Ribble Valley Borough Council
Housing & Development Control

App no: 3/2024/0400

Address: Whalley Railway Viaduct Broad Lane Whalley BB7 9RS

Proposal: Approval of details reserved by condition 5 (traffic management plan) of listed building consent 3/2024/0083.

SITE TRAFFIC

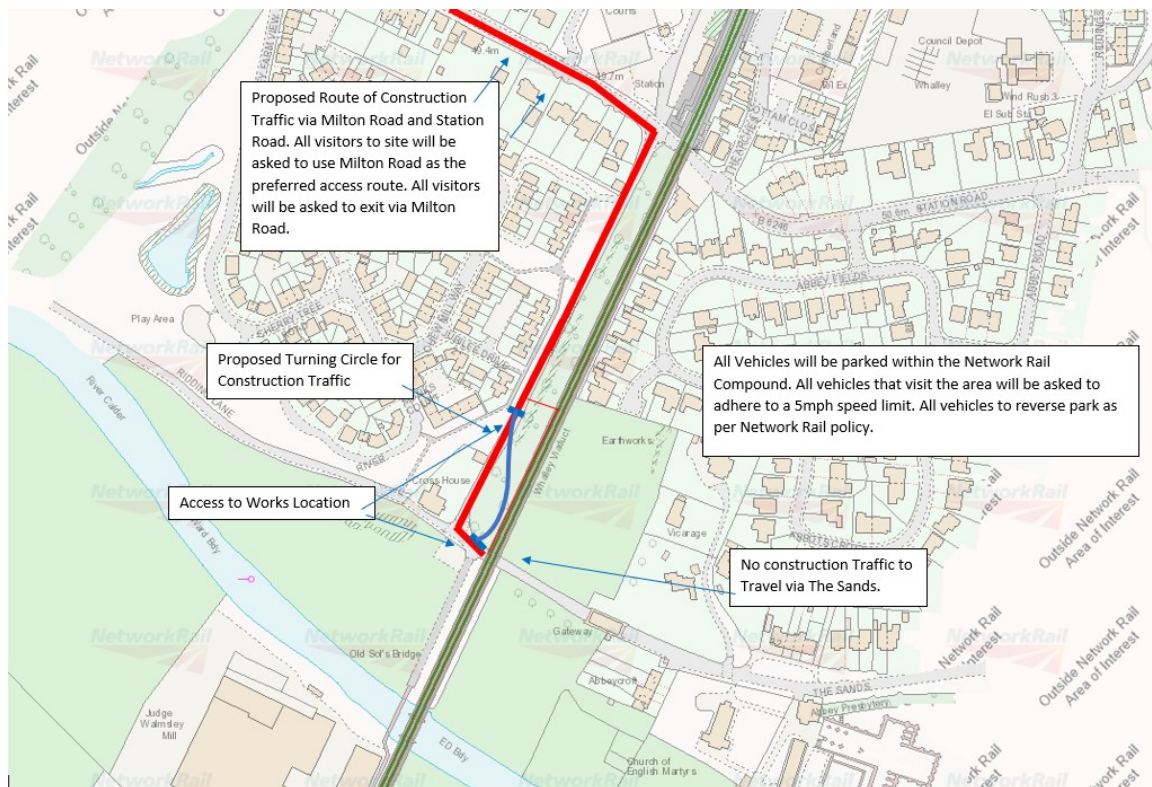
There are two proposed site accesses to be created one on The Sands by removing a section of stone wall close to the junction of Broad Lane and the second on Broad Lane approximately 75m north of The Sands. Visibility for emerging vehicles is limited due to the proximity of the bend and the viaduct and at the second access it is limited due to the heavy vegetation along the boundary. Visibility should be provided at the site access at a set back distance of 2.4m by 25 in both directions along the highway as both are subject to a 20mph speed limit.

Routing of construction traffic is proposed in the immediate area via Mitton Road B6246 and Broad Lane. There is a low railway bridge on Station Road B6246 12'6 and a 3t weight and height restriction 14'6 on The Sands.

There are no mitigation measures submitted for the trees overhanging Broad Lane which may present an issue for high sided vehicles. Therefore, we have assumed that no trimming back of the trees overhanging the highway is required.

There is no objection to the discharge of this condition, and we expect Network Rail to implement the necessary measures to mitigate the potential highway safety matters as discussed above prior to the construction phase commencing.
